CITY OF ALBUQUERQUE

March 23, 2018

Re: TLS Training Kitchen Addition
5601 Domingo Rd. NE
Traffic Circulation Layout
Architect's Stamp 03-22-18 (K18-D107)

A1 PROPOSED PARKING LAYOUT
SCALE: 1" = 10'-0"

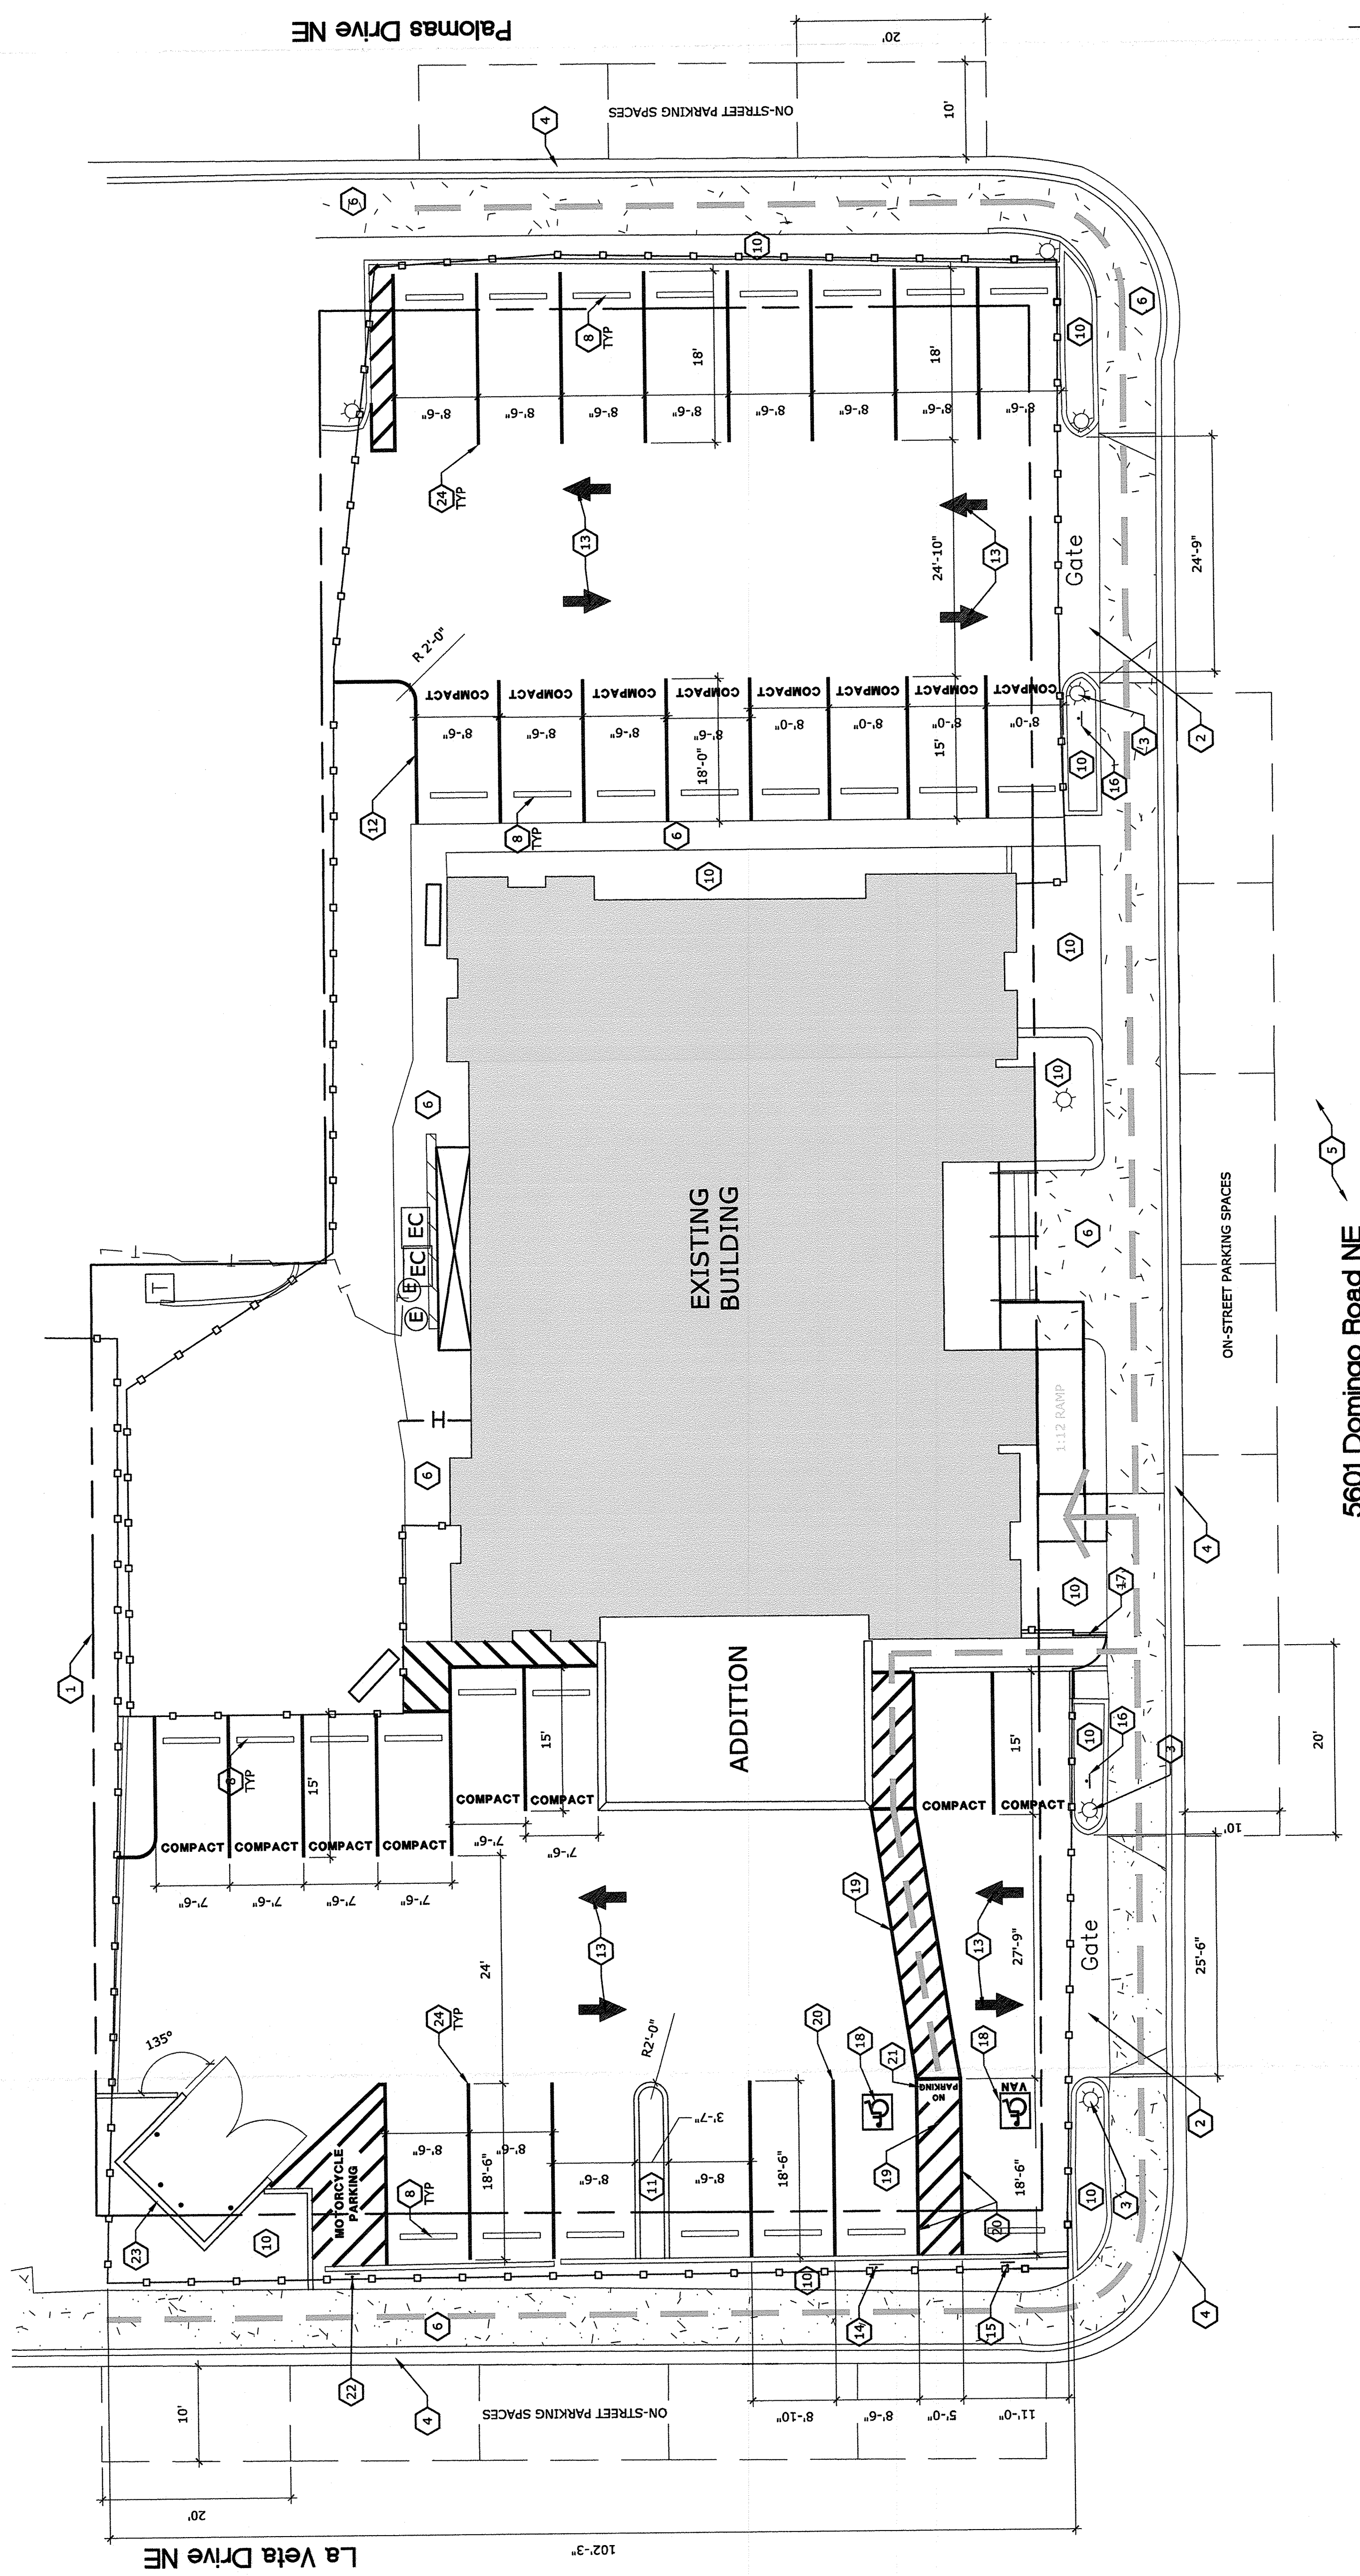
1. A 5 ft. keyway is required for dead-end parking aisles. Please make the compact spaces on the west side 7.5 feet wide to accommodate as much of a keyway as possible.
2. Make the parking spaces on the Westside 18 feet long to get the 24 feet for two way traffic. (ADA parking spaces can be a minimum of 18 feet long)
3. Please make all the parking spaces on the east side of the building Compact to make the drive aisle 24 feet wide.
